From: Roger Spencer
Sent: 21 November 2017 16:31
To: Planning.Responses
Subject: RE: Planning Consultation on: FP/268/17/PL

The following is a response particularly in respect of coastal defence.

APPLICATION **FP/268/17/PL**

Description of Works: Detached 9No. bedroom annexe for Beachcroft Hotel with
9No. car parking spaces.

Timber Planks to be fixed without gaps, to the timber posts, sitting on top of the existing seawall.

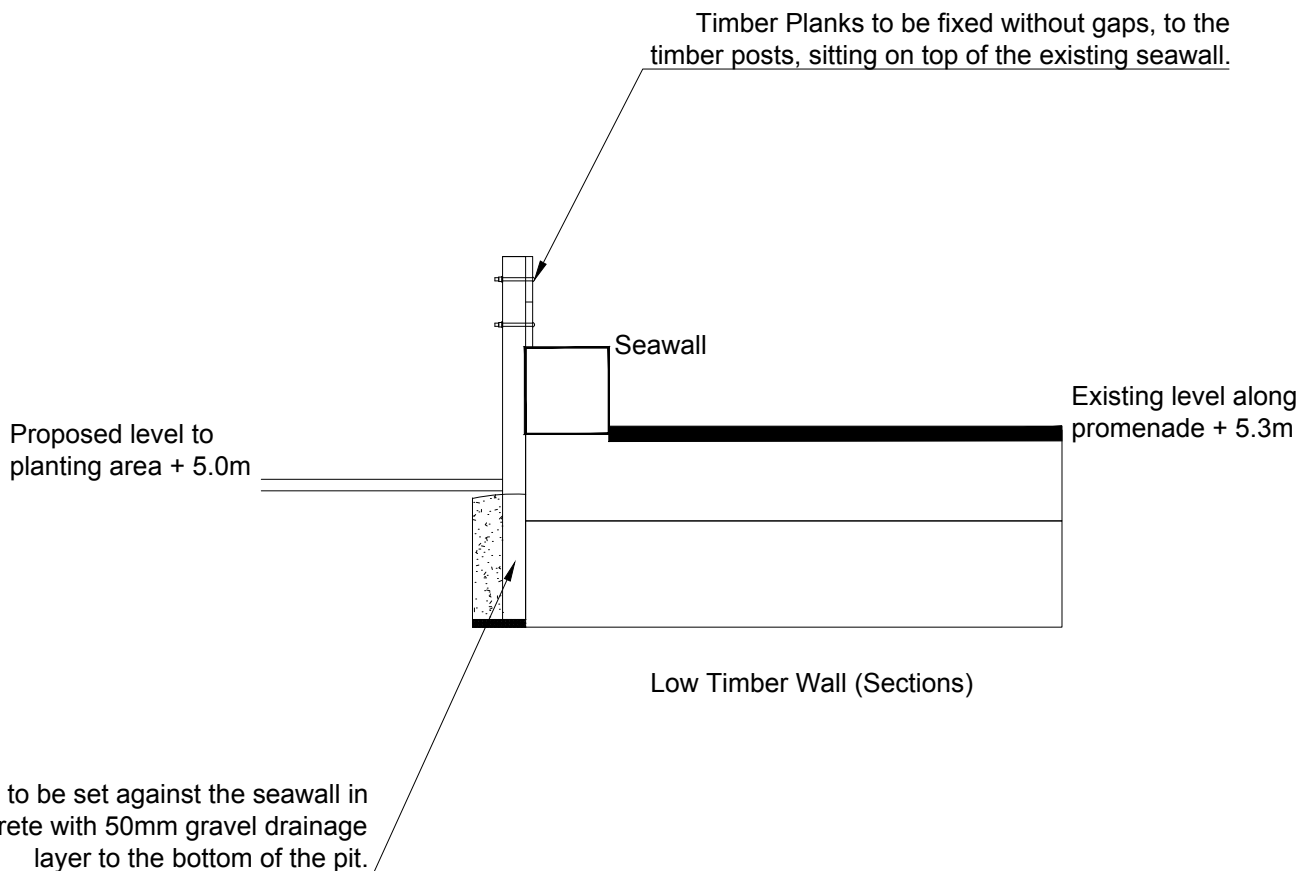
The site is immediately adjacent to the rear splash wall of the coastal defence; that rear splash wall has an access through it which is currently provided with 'stop logs' to reduce the risk of water and shingle entering the site.

I appreciate the fact that the ground floor will be undercroft car parking and therefore there is low risk. However, there is a history of shingle over-wash into the site. Most recently, the stop-logs were damaged which resulted in further shingle deposition within the site.

I would suggest that the development be provided with a higher, more robust and continuous eastern boundary feature to reduce the risk of shingle and water over-wash into the site. This may reduce lighting levels in the undercroft but it would not detract from views afforded to the suites.
